**Orora (formerly AMCOR) New Paper Mill Project, Matraville
Proposed Modification - Additional demolition works**

I refer to your e-mail dated 24 February 2015 inviting the Environment Protection Authority (EPA) to make a submission on the application from Orora to modify its project approval (MP 05_0120) for the New Paper Mill Project at Matraville.

The EPA understands that the proposal involves the demolition of the existing fire damaged B7 building, minor alteration to the subdivision plan and relocation of existing site access from McCauley Street.

Stage 1 Mitigation - 7.5 m container wall plus earth mound

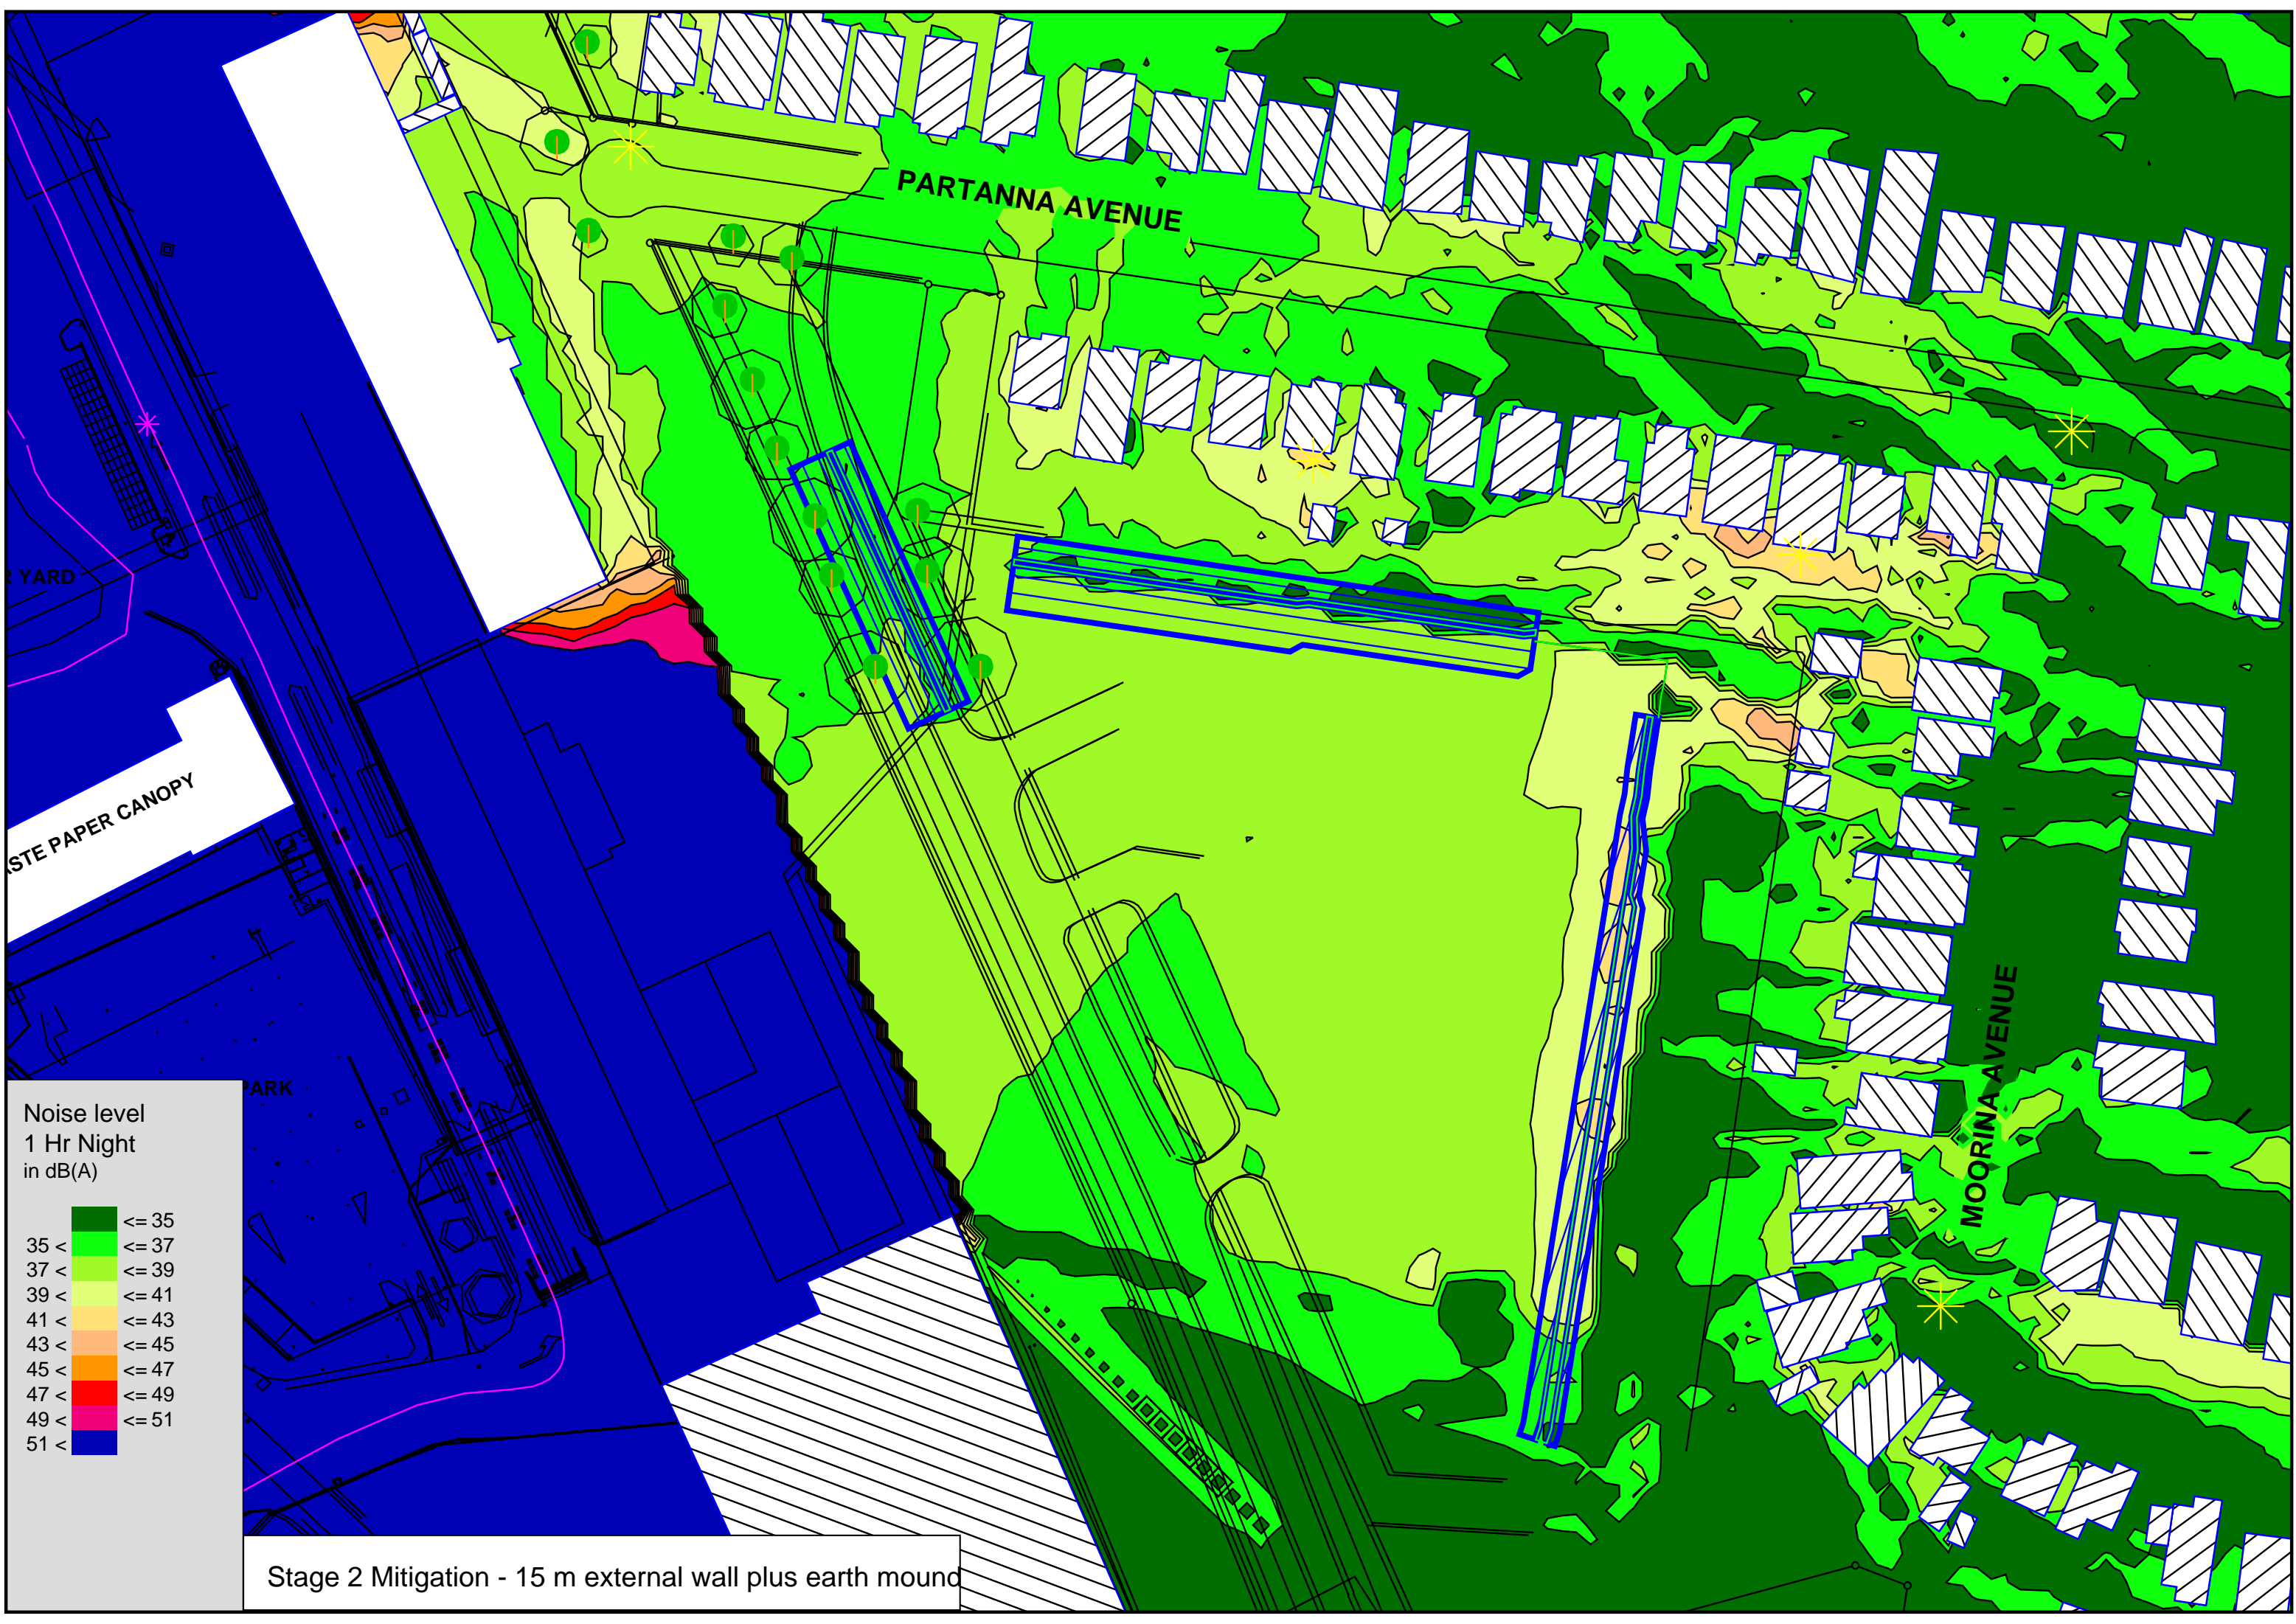
Modelling of predicted operational noise levels following the removal of the B7 building has shown that the addition of an 8 metre noise wall reduces the noise levels at many of the locations. However, it is noted that the location and finished height of the modelled wall is only indicative at this time and would be subject to the survey and feasibility constraints for the site once B7 is removed. It is further noted that even with an 8 metre noise wall, it is expected that there will be marginal exceedances of the noise limits at some locations.

Demolition of the B7 building will remove a significant source of shielding from Orora's operations, the surrounding roads and the Port Botany Precinct. The EPA is concerned that there is insufficient certainty that operational noise levels will meet the current noise levels following removal of the B7 building.

Accordingly, the EPA requests that a clear timeframe is provided for the noise wall survey and feasibility studies, additional noise monitoring and Noise Barrier Design Plan. Consideration must also be given to what additional noise mitigation and management measures may be available if the proposed noise barrier is unable to reduce noise levels to the meet the current noise limits for the site.
